From: hda projects [REDACTED]
Sent: 02 December 2019 15:00
To: Finlay Gardner <Finlay.Gardner@arun.gov.uk>
Subject: RE: Application BN/112/19/CLP Hangleton, 32 Halliford Drive, Barnham

BN/112/19/CLP Hangleton, 32 Halliford Drive, Barnham

Title
Elevations as Proposed

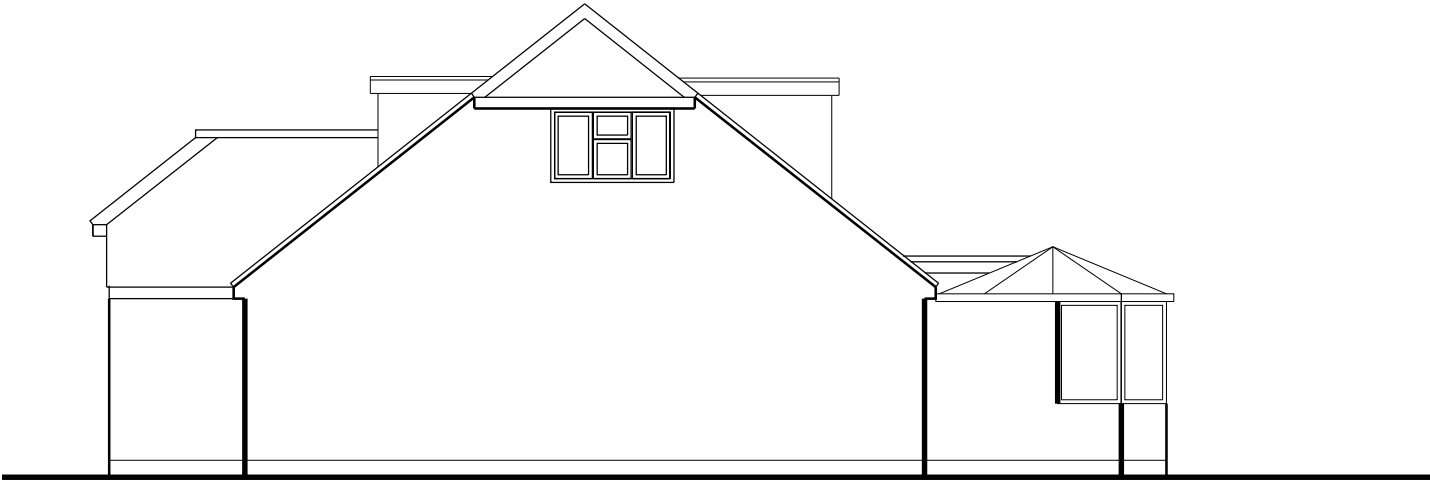
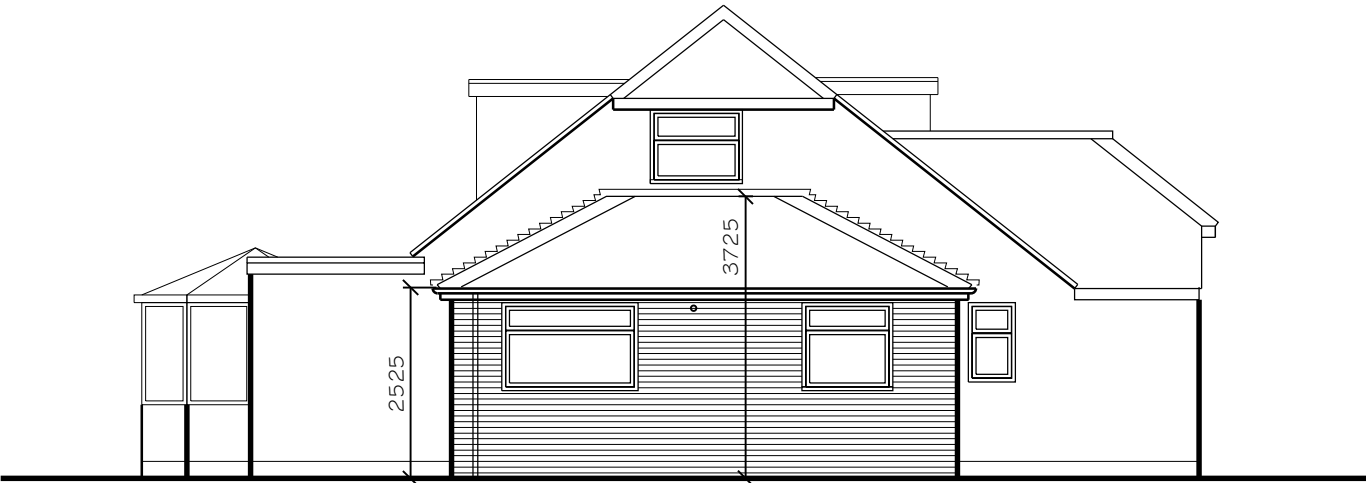
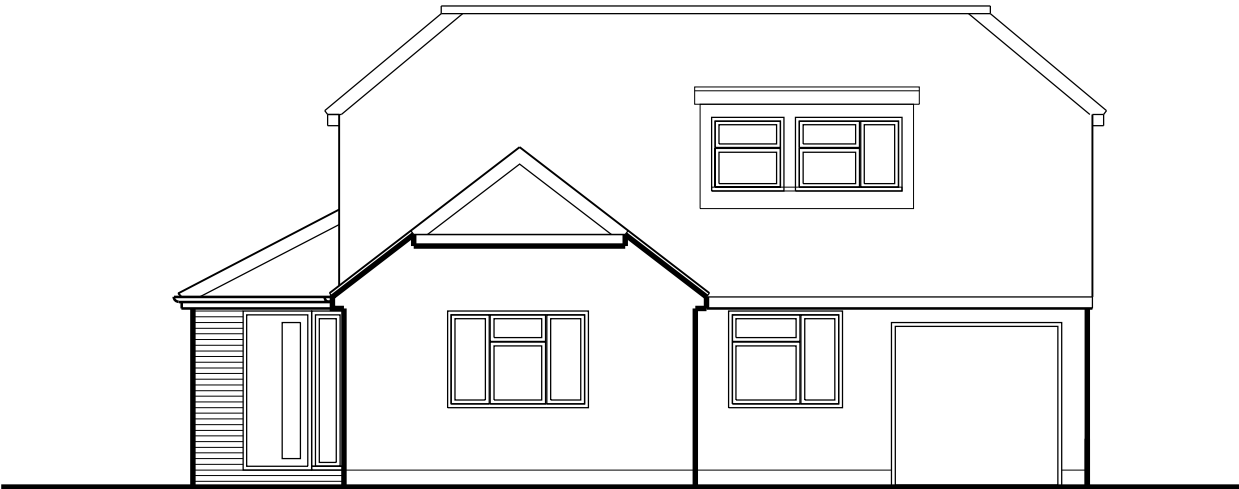
I am writing to you with regards to application BN/112/19/CLP (Hangleton, 32 Halliford Drive, Barnham). I need to know the intended materials to be used on the side extension in relation to the existing in order for the application to have a decision. If you could let me know the materials as soon as possible then I will be able to get a decision to you.

Further to your request we can confirm the external wall finish will be brickwork, roof - plain tiles and windows white plastics, all to match existing
